CITY OF ALBUQUERQUE

**Re: First Nations Community Health Source,
Buildings A, BP-2017-43088 & B, BP-2017-44384
5608 Zuni Rd. SE, 87108
30-Day Temporary Certificate of Occupancy- Traffic Certification Only
Transportation Development Final Inspection
Engineer's/Architect's Stamp dated 07-28-17 (L18D047)
Certification dated 2-6-19**

SHEET TITLE  
**ARCHITECTURAL  
SITE PLAN FOR  
TRAFFIC CIRCULATION  
LAYOUT**

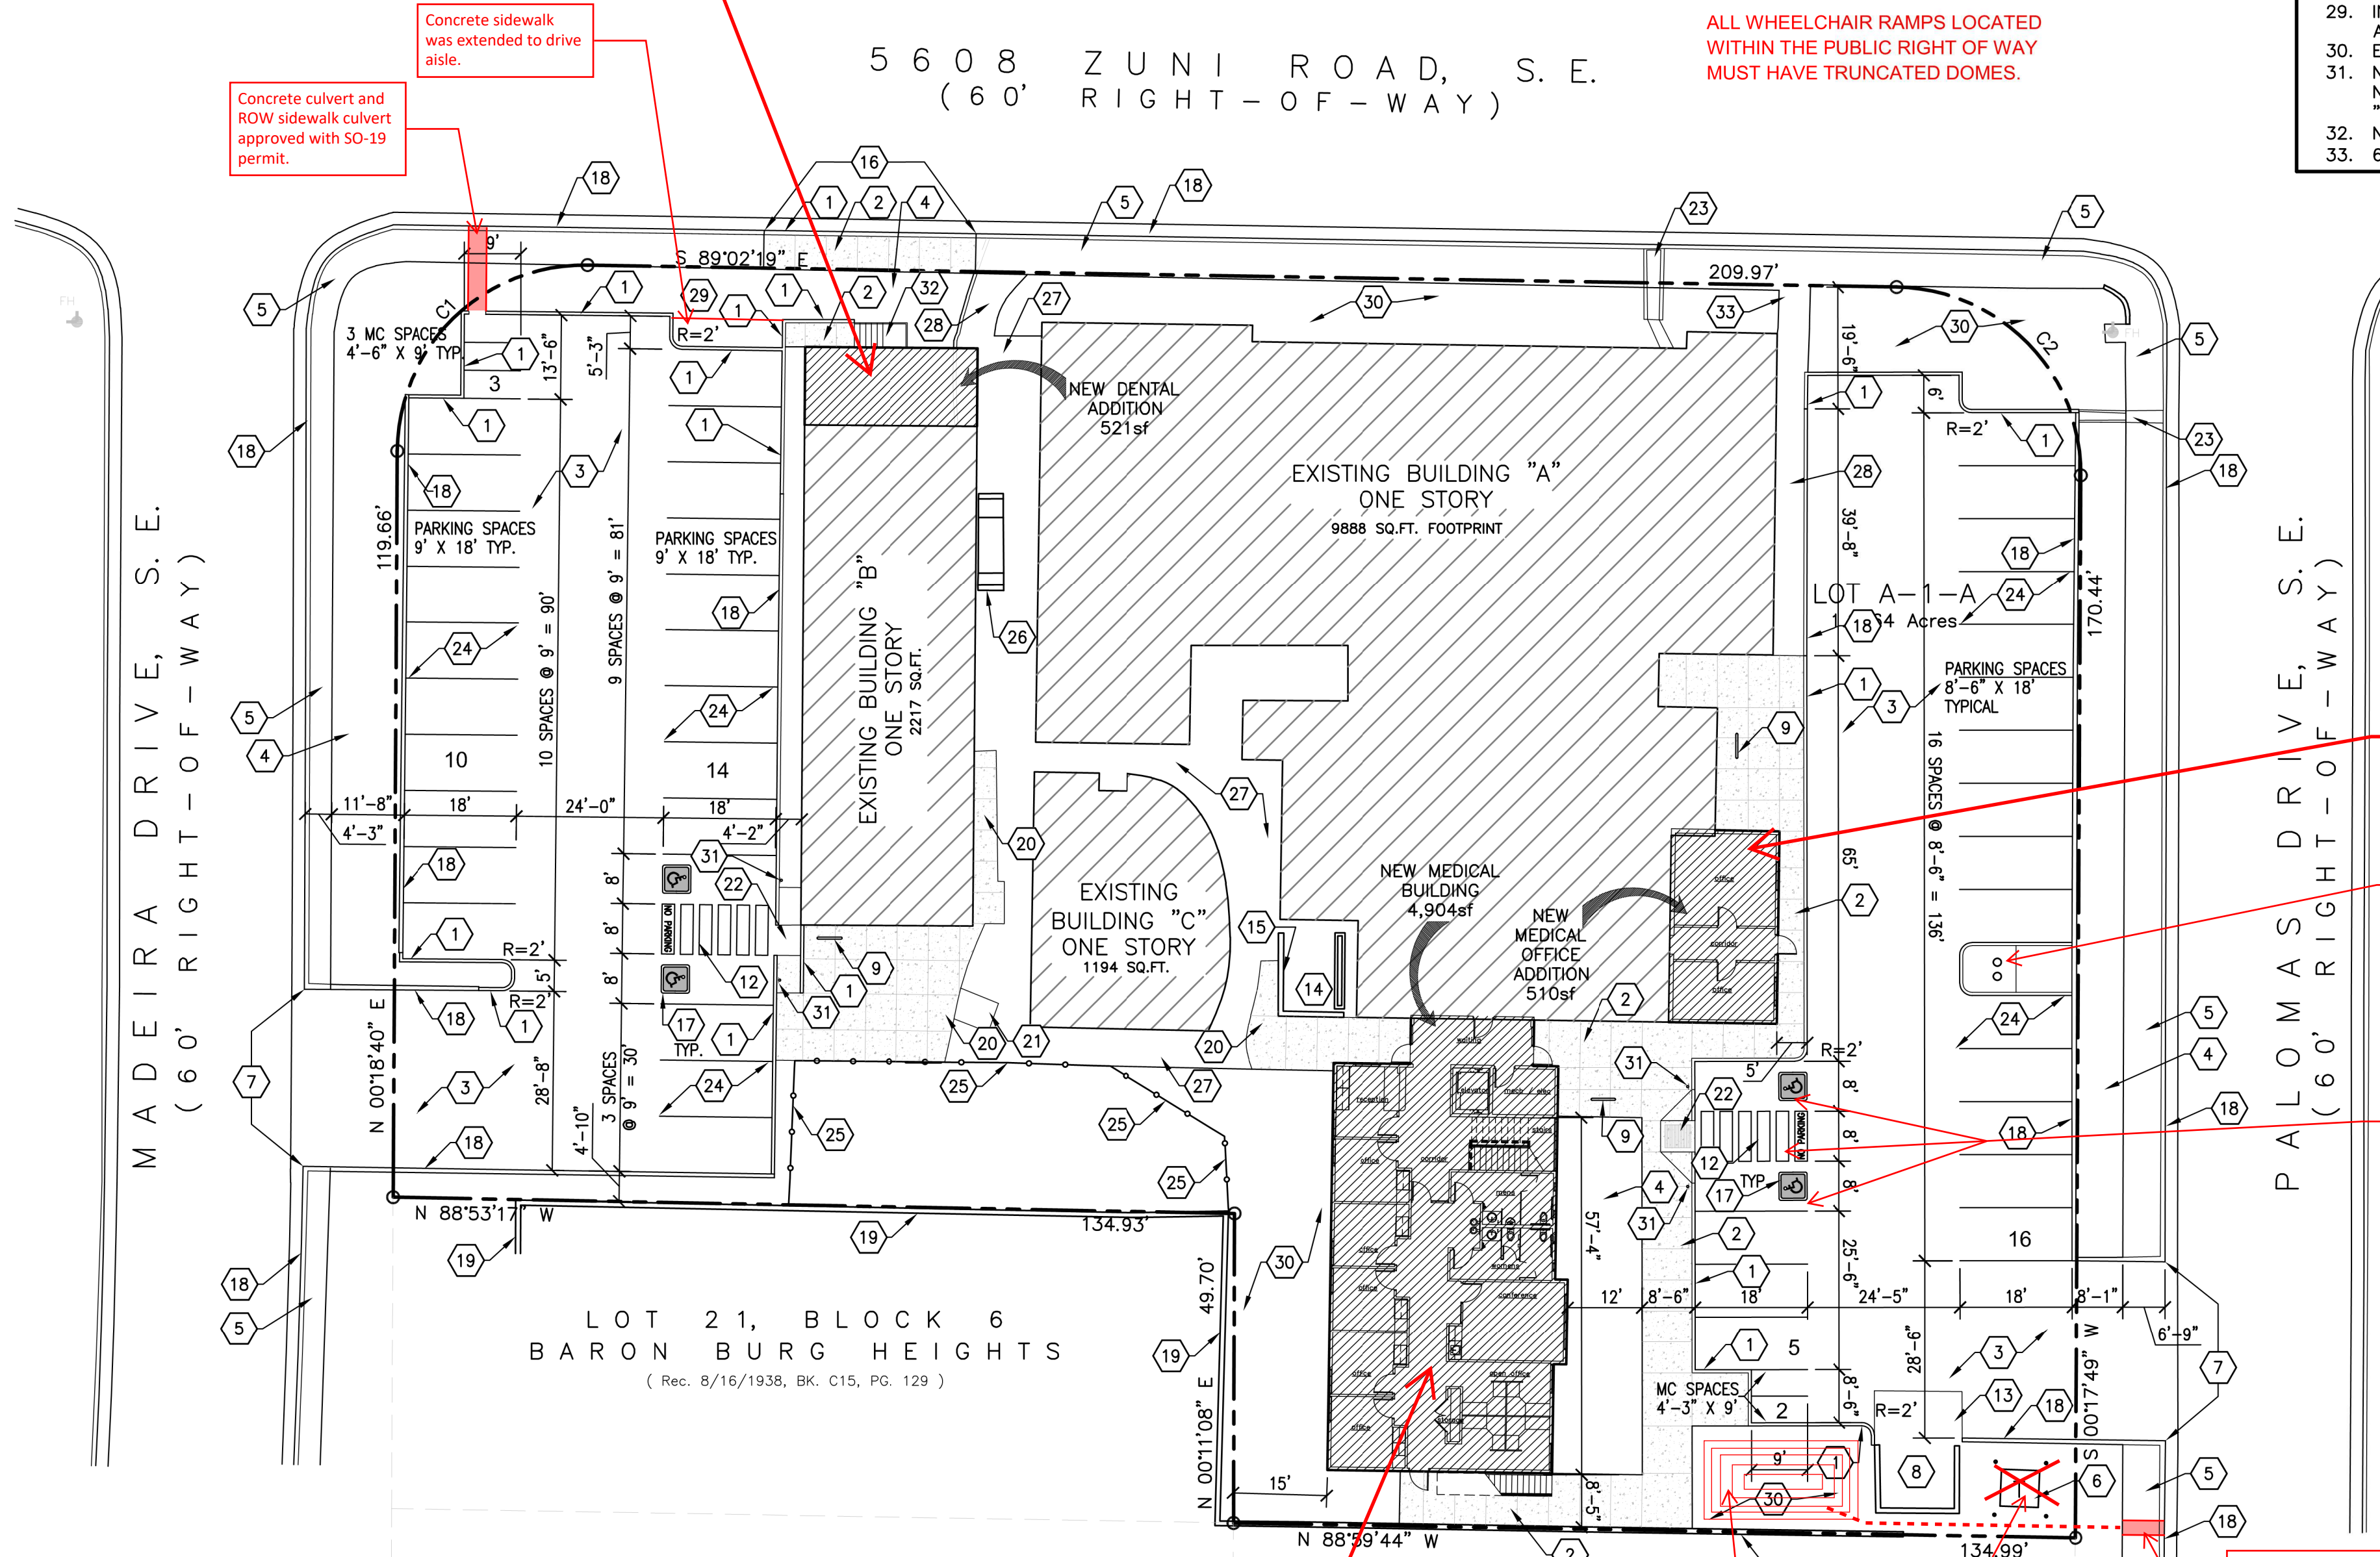
1. Please remove security fence.
2. Send an electronic photos of your corrections to PLNDRS@cabq.gov &
epgomez@cabq.gov for final CO for buildings **A & B**.
